April 23, 2024

The following comments are the Environmental Public Health comments on the LP-24-00002 Nelson View – Notice of Application.

NELSON VIEW PLAT PREPARED FOR NELSON VIEW LLC A PORTION OF THE SOUTHEAST QUARTER OF SECTION 20 TOWNSHIP 20 NORTH, RANGE 14 EAST, W.M. KITITITAS COUNTY WASHINGTON		
DWN BY	DATE	JOB NO.
DLP/GW/DBM	03/2024	230165
CHKD BY	SCALE	SHEET
DLP/DBM	1"=200'	2 OF 2

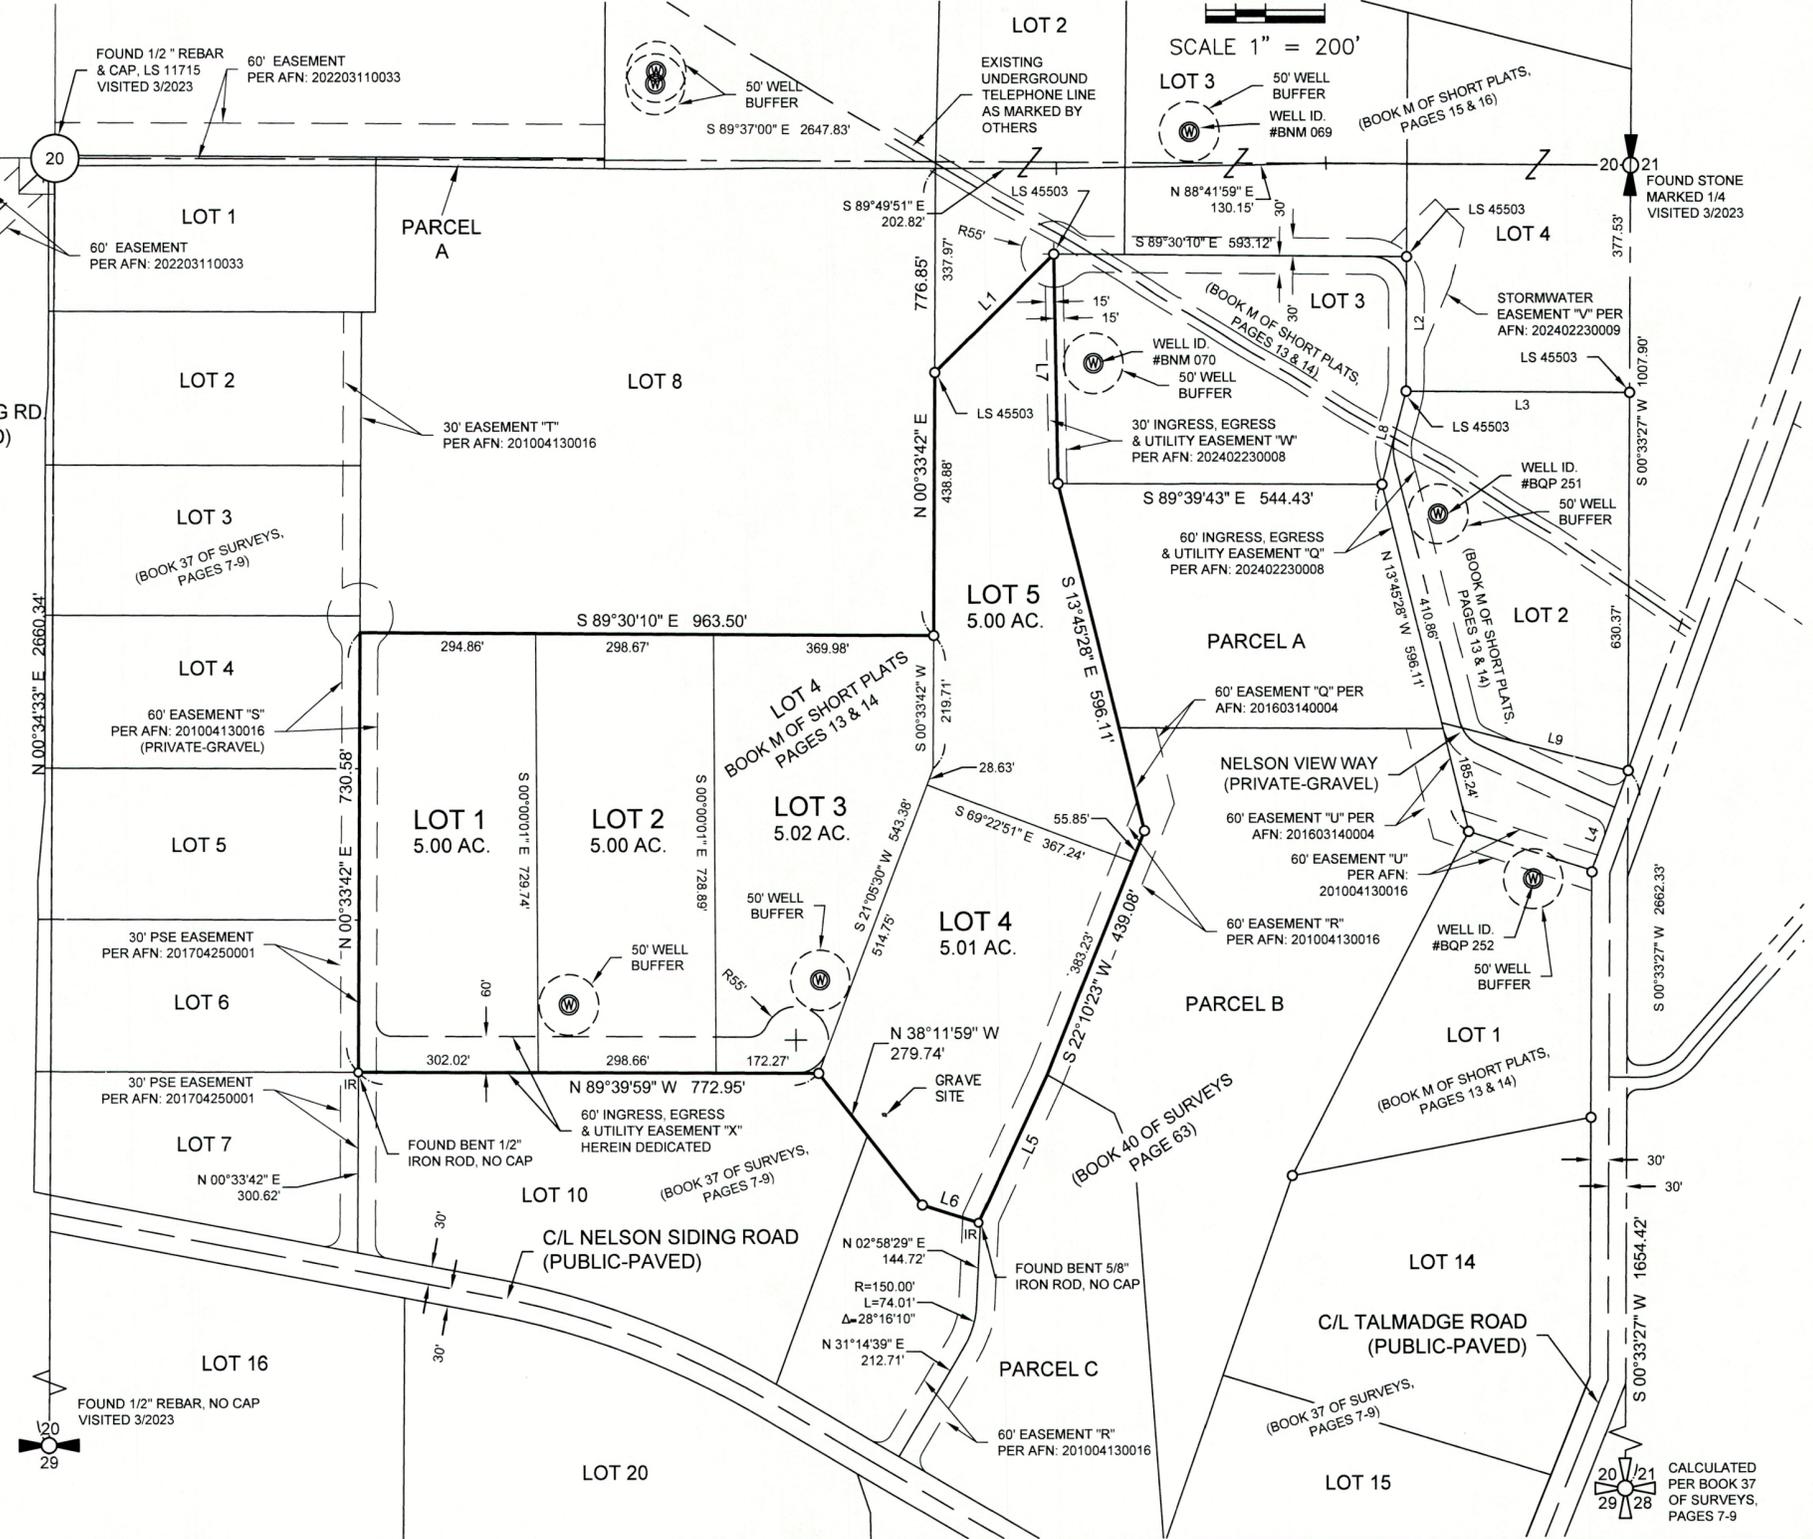
The applicant is proposing to share a well between proposed lots 1 and 2, and proposed lots 3 and 4. Since the well driller could not access the property last fall, the wells were to be drilled this spring. Public health needs the well logs for those two wells prior to final plat signature. Everything else required has been completed and submitted.
